Our Ref: ID 3867
Your Ref: SSD-48160216

17 June 2026

State Significant Development Application for Maison Dieu Solar Farm (RtS)

Figure 3.4 Hunter River flood constraints

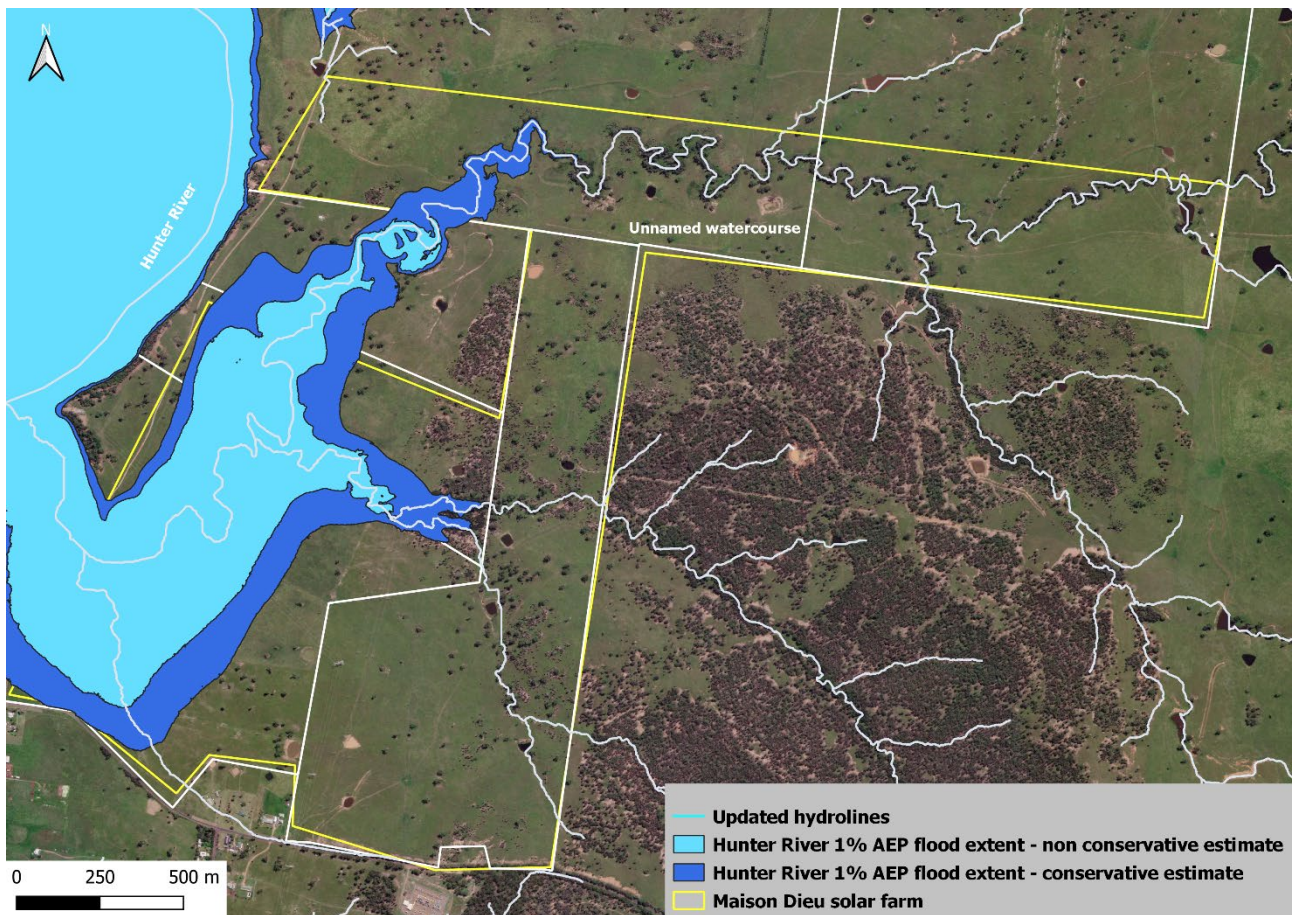
The Hunter River is located to the east of the site. Parts of the Site may be on land that is prone to Hunter River and local flooding.¹ While the current design addresses the 1% AEP event, it does not adequately consider the full range of risks up to and including the PMF.

- **Recommend** requesting further information regarding flood and isolation risks up to and including the PMF.² There is a risk of inundation, structural damage, and safety hazards during extreme flood events. The site lies within the Hunter River floodplain and is intersected by a floodway. Additionally, several unnamed 1st–4th order watercourses traverse the site, discharging into the Hunter River. These features contribute to a complex flood behaviour, with the potential for concentrated flows and elevated flood impacts.³

- **Recommend** the definition and application of freeboard is reviewed within the EIS, as it is incorrect and therefore inadequate. The Flooding Assessment (EIS Appendix L) identifies floor levels set at 1% AEP + 500 mm freeboard, described as “distance from the waterline.” This definition is technically incorrect as freeboard should reflect a
